Application for removal or variation of a condition following grant of
planning permission. Town and Country Planning Act 1990.
Planning (Listed Buildings and Conservation Areas) Act 1990

Retention and alterations to existing dwelling and the erection of 1 no. new detached property and 2 no. semi-detached properties with associated car parking, garages, external landscaping and boundary treatments

124282/FO/2019

Approved drawing numbers as listed on the approval to be substituted by revised scheme drawing numbers 13,542/22F & 23C

GROUND FLOOR PLAN
(Plot 4) - 4b/7p @ 129.0m²
@ MIN. 1.5M C.H.T. excl. garage

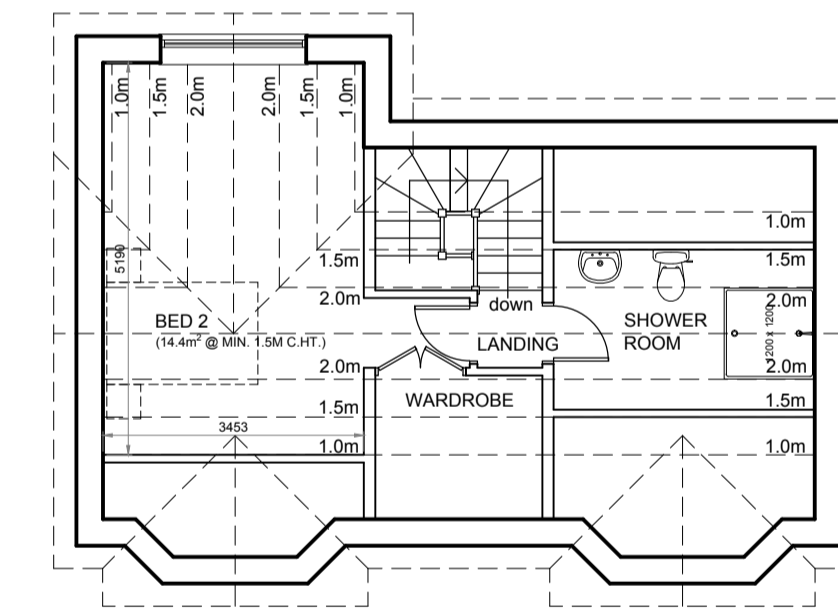
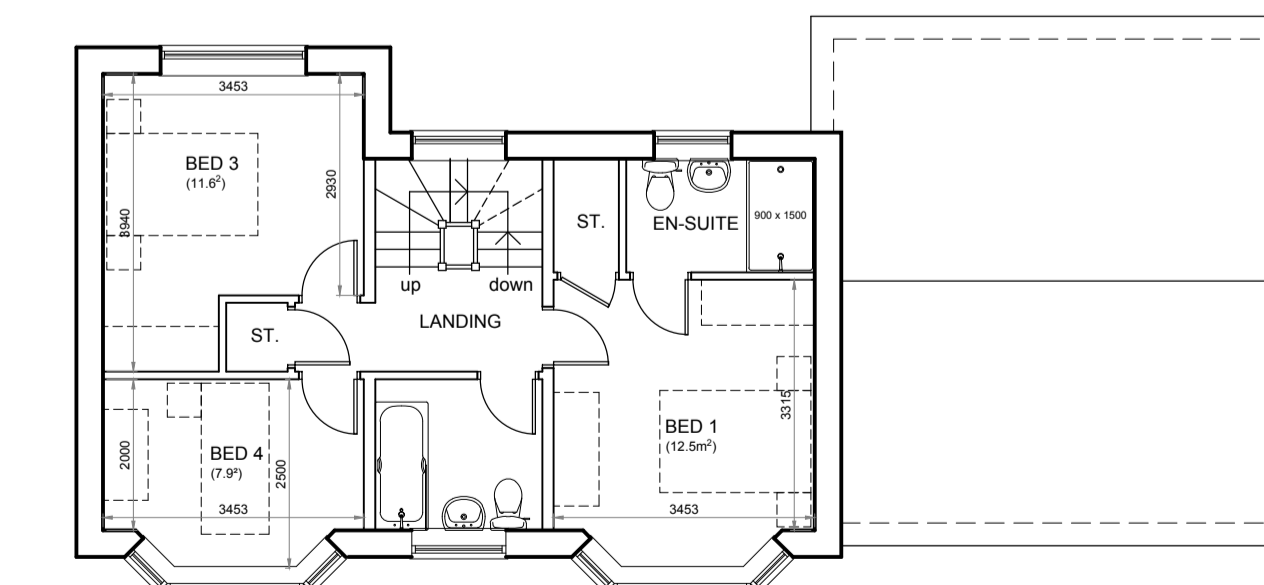
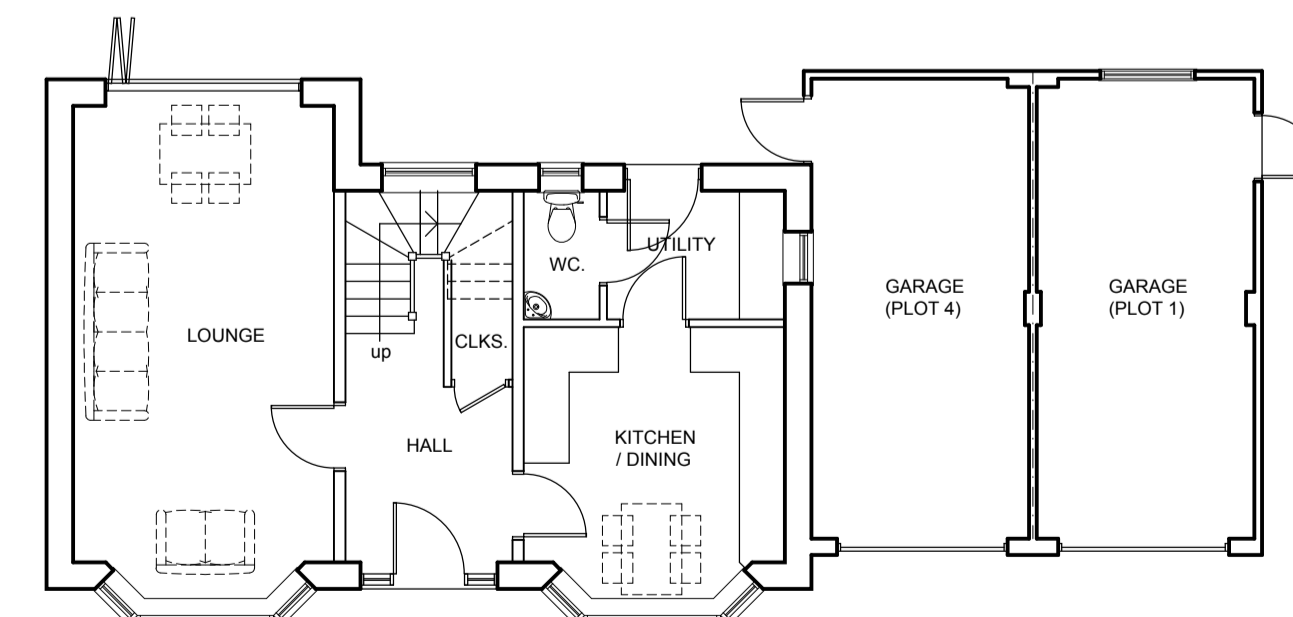
The site plan has been revised to provide Plot No. 4 with a larger garden and an additional parking area for Plot No. 1. The kitchen layout has been revised on Plot No 4 from the approved layout, and roof lights are proposed to provide natural light to the top floor of Plot No. 4.
